Application no: H17-0499-15

Description: Proposed two storey extension.

Location: 4 LOW GATE
SURFLEET
SPALDING
PE11 4AS

ACKNOWLEDGEMENT OF AMENDMENT

Scale 1:50&1:100@A1	Date June 2015	
Ref. 2205	Number _A_3103	Rev. A

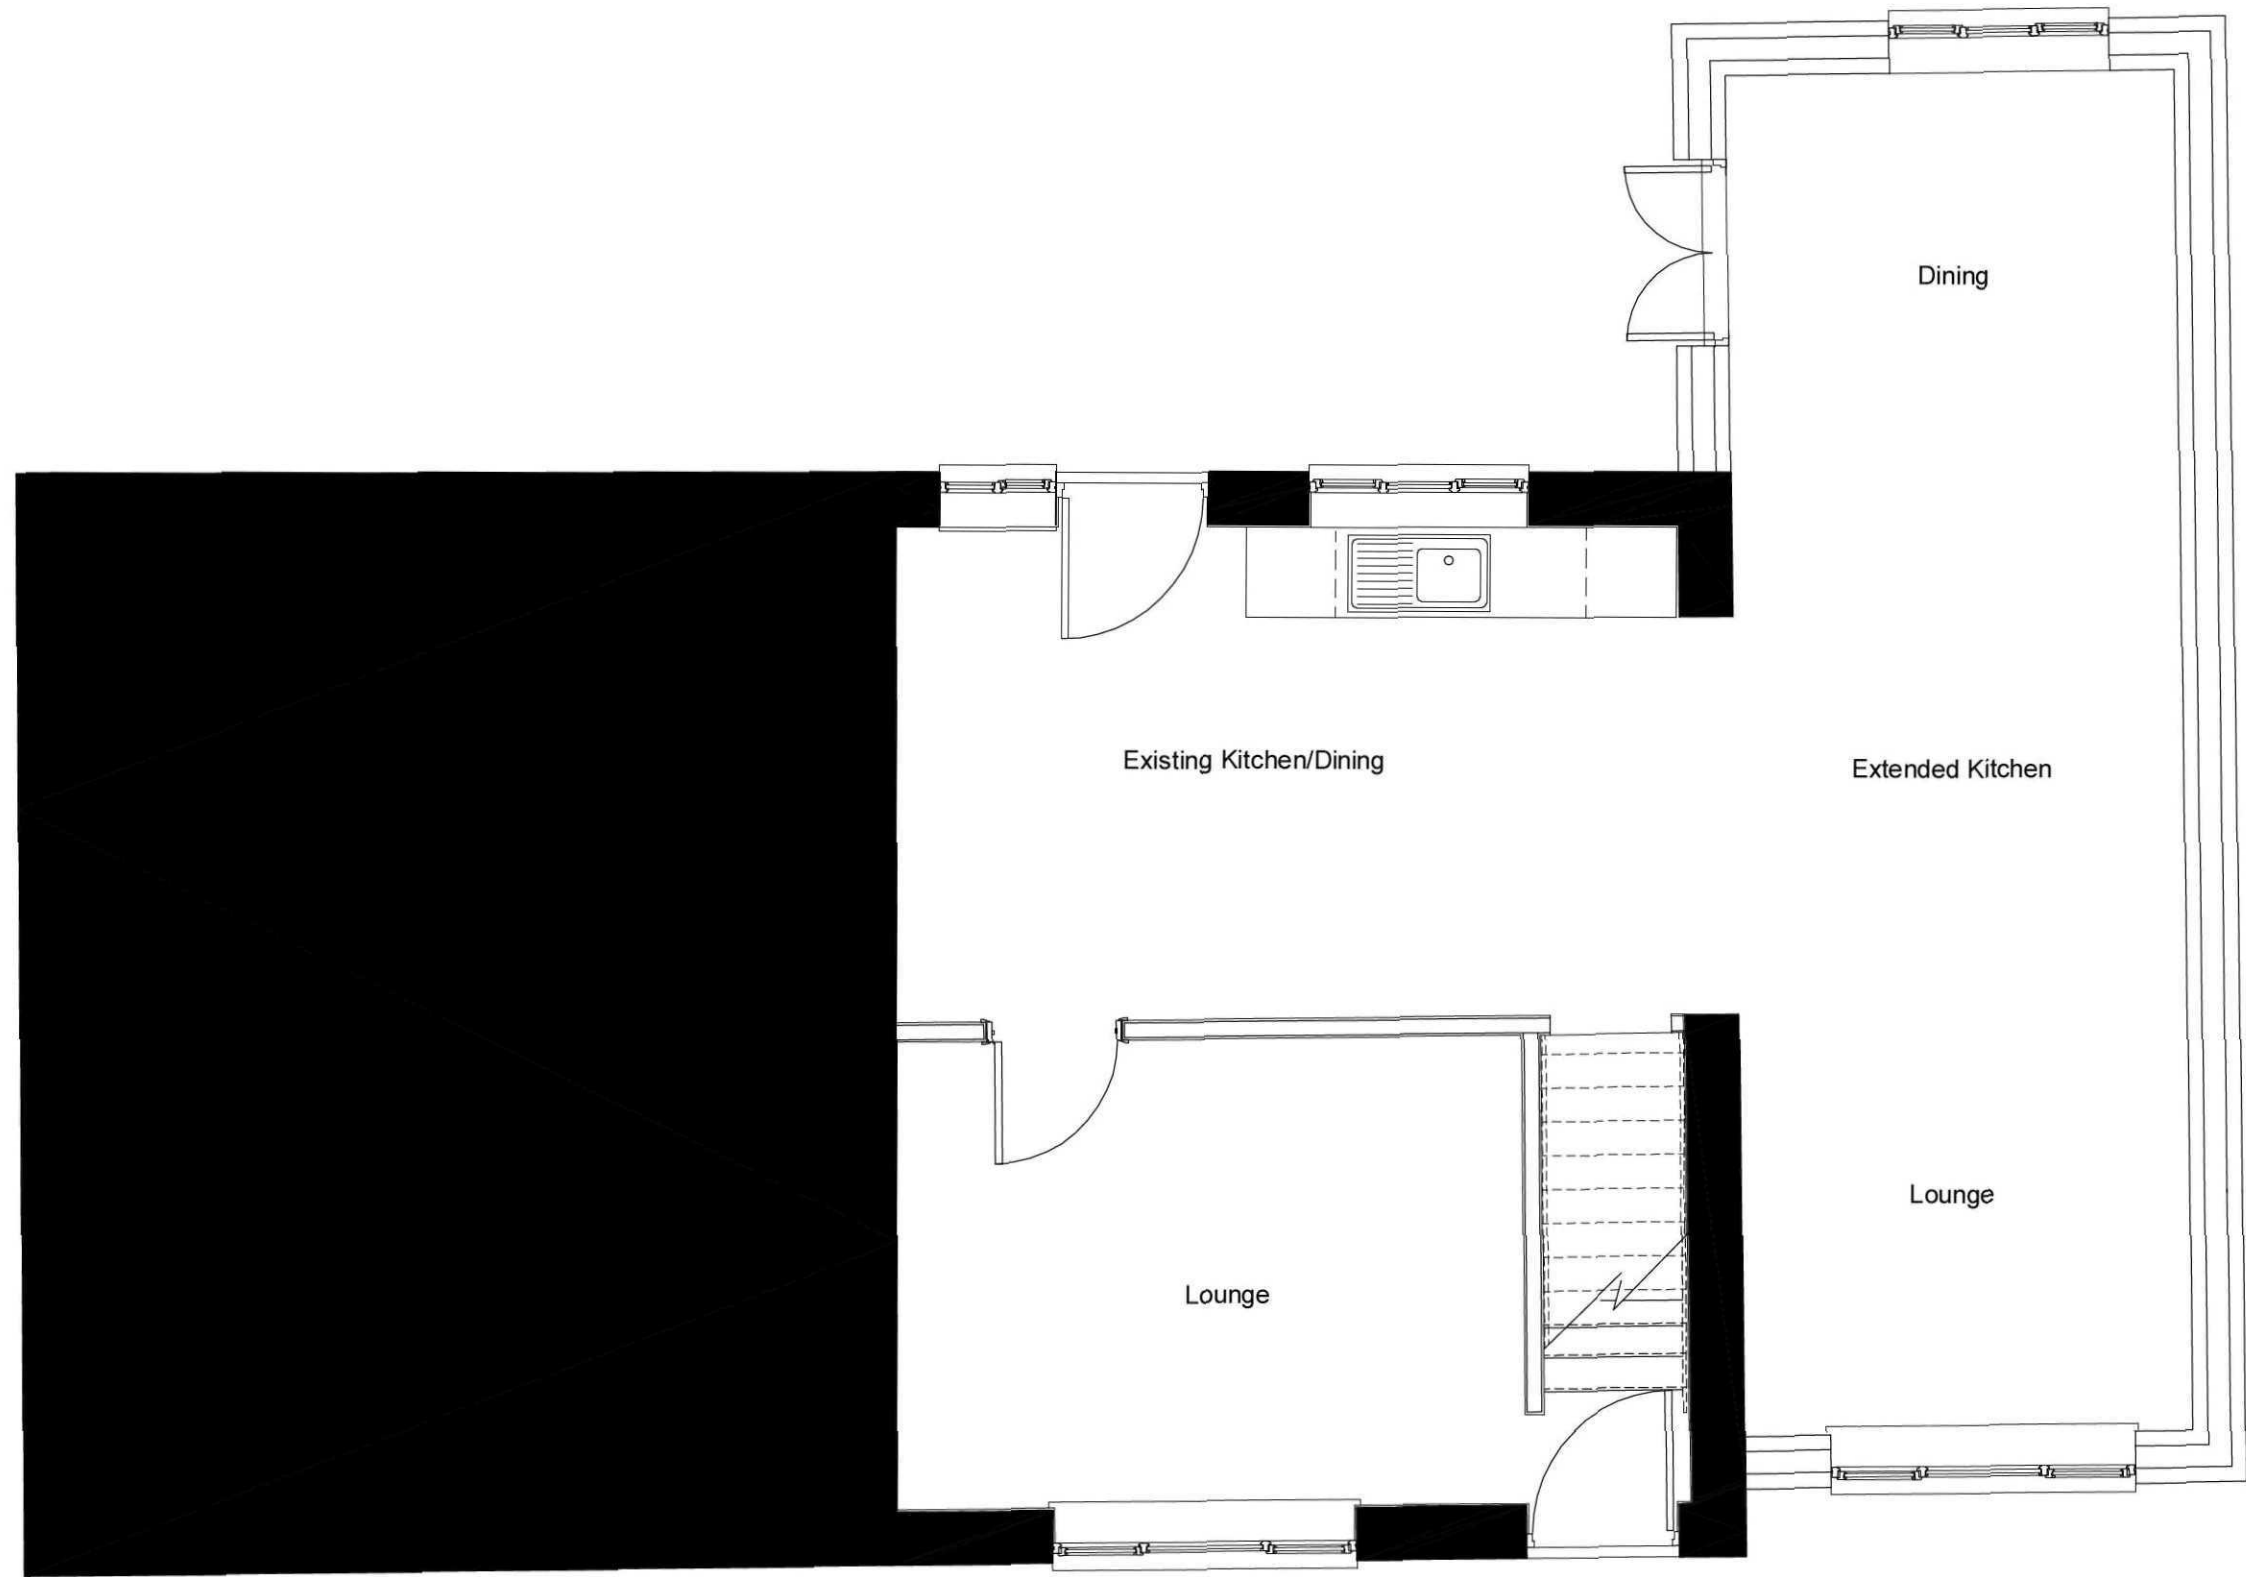
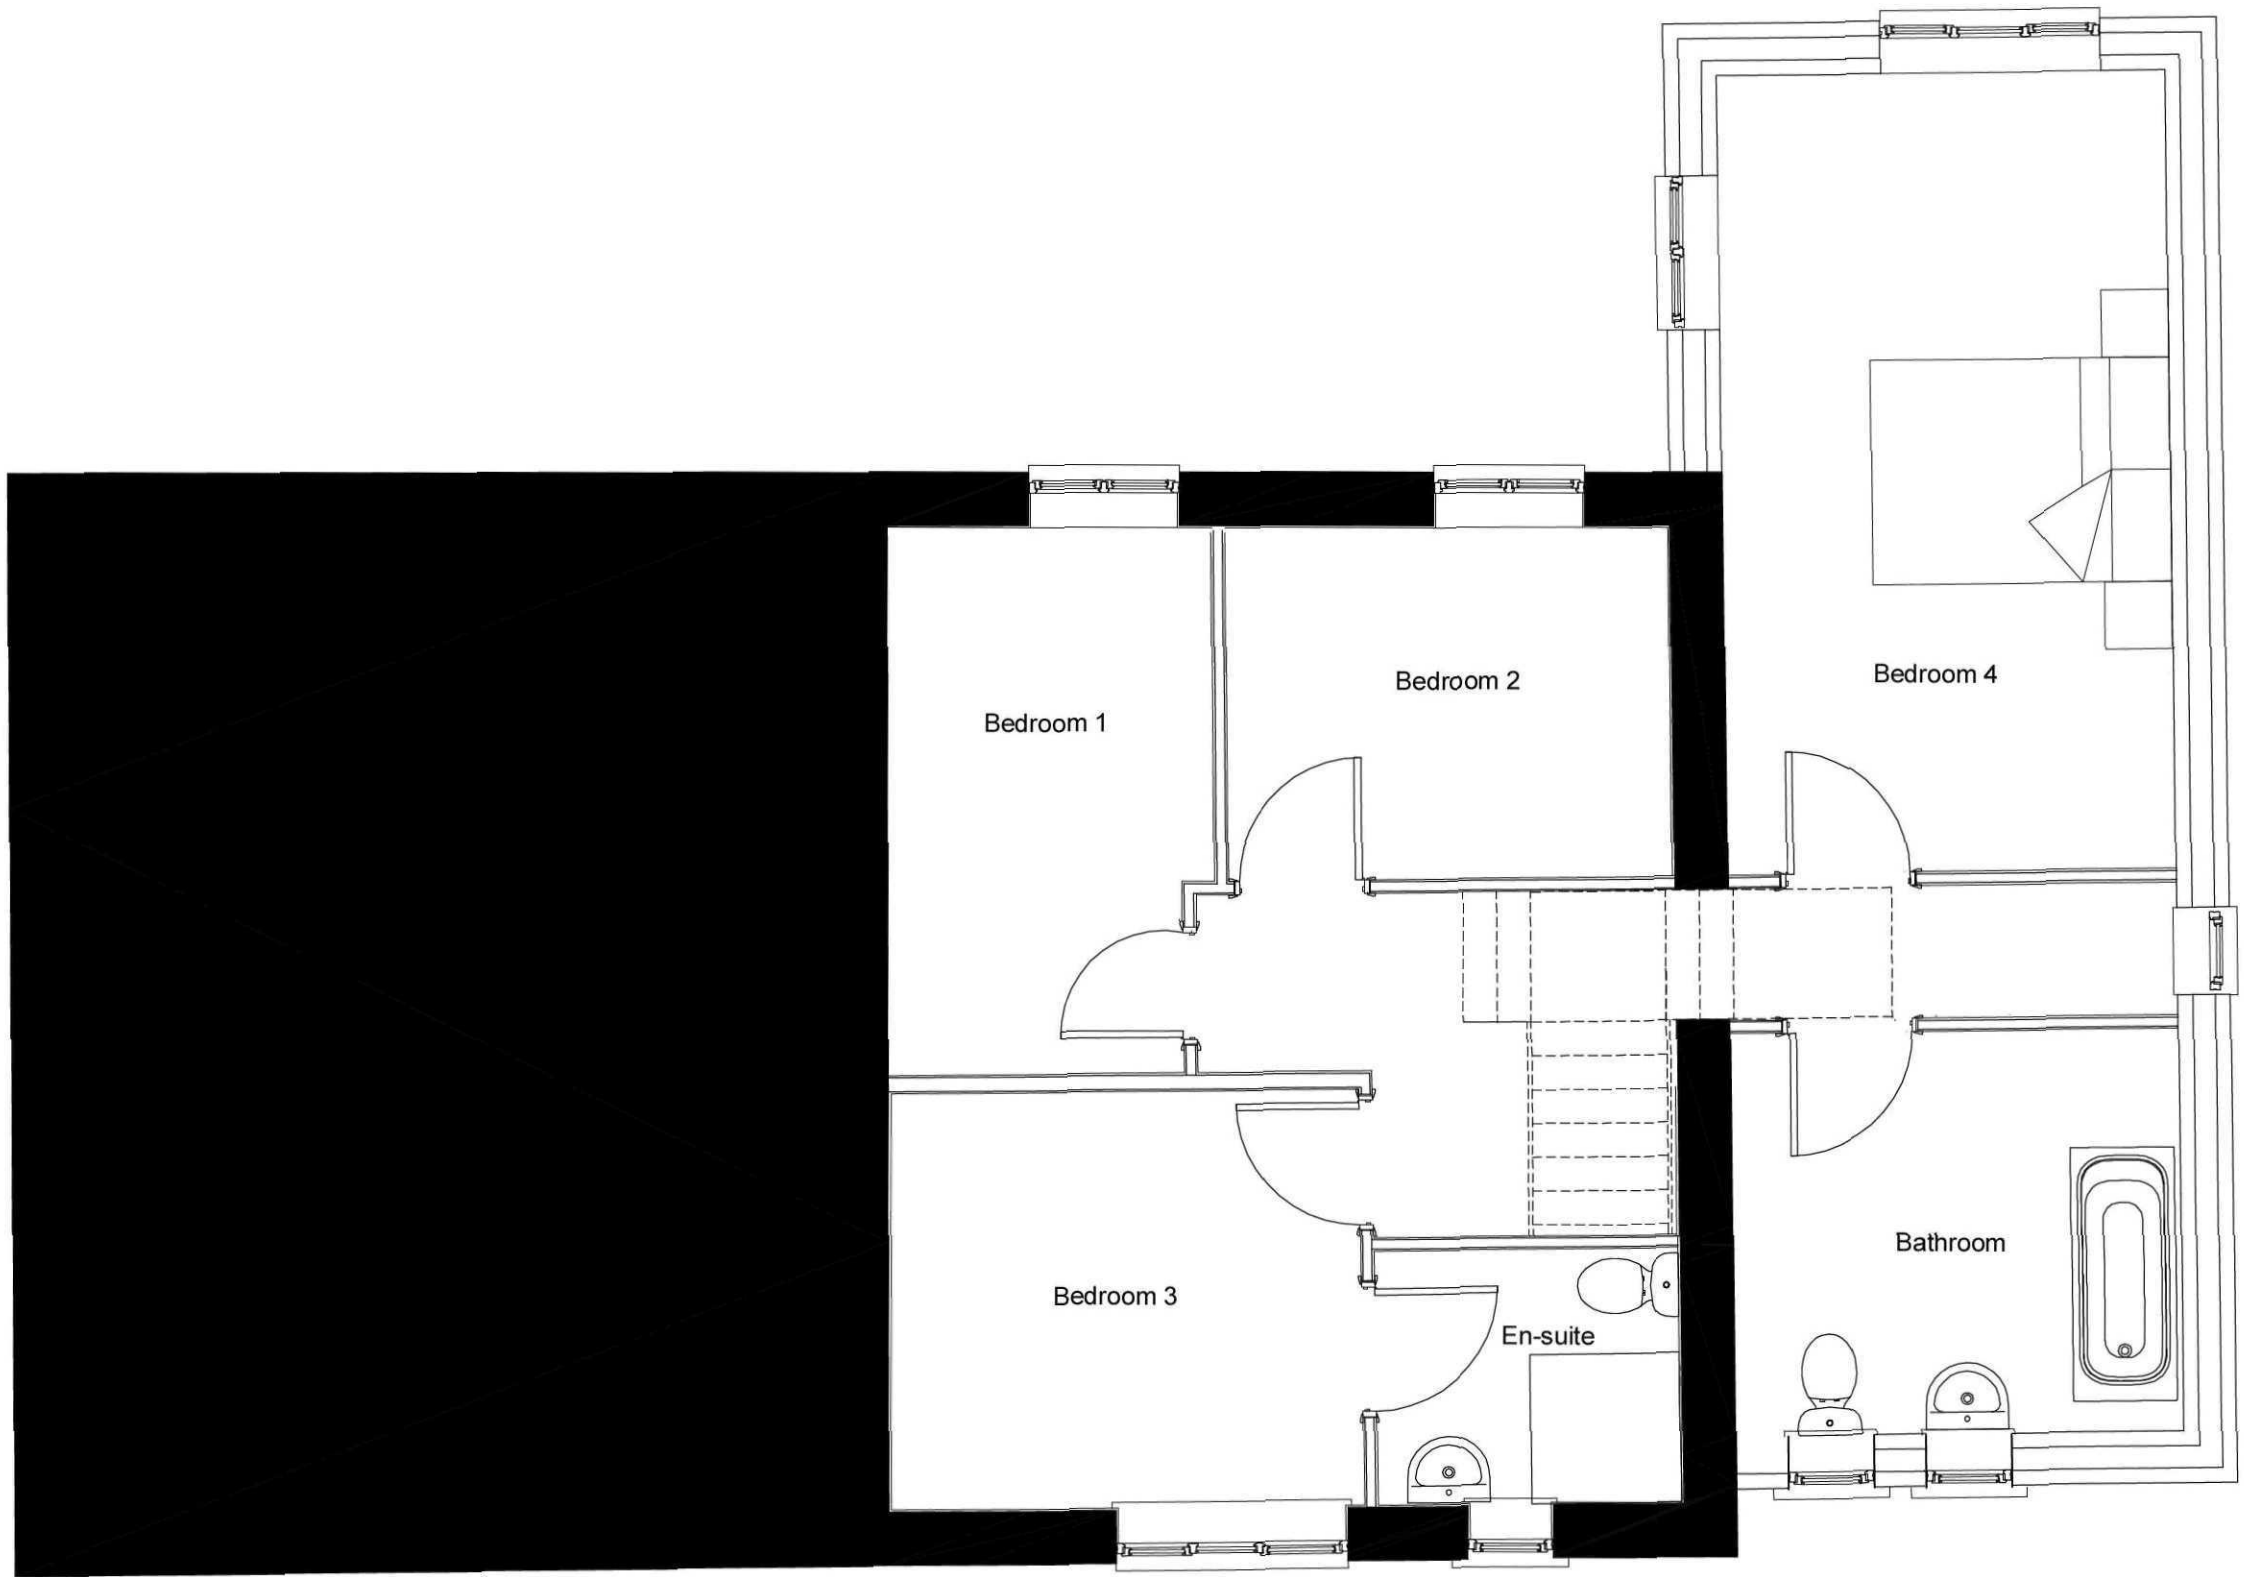
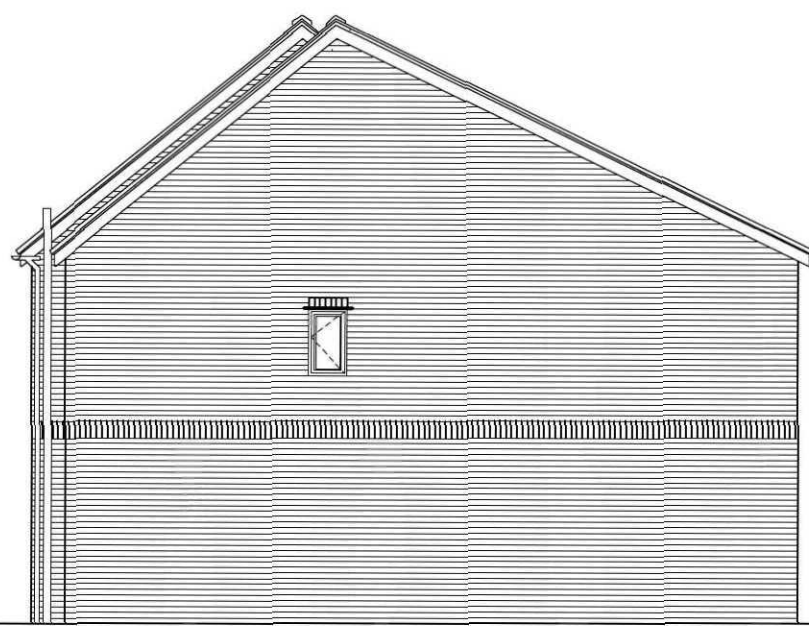
- To label the hallway as obscure glazed
- To reduce the two storey extension where it projects to the rear from 3 metres to 1.5 metres
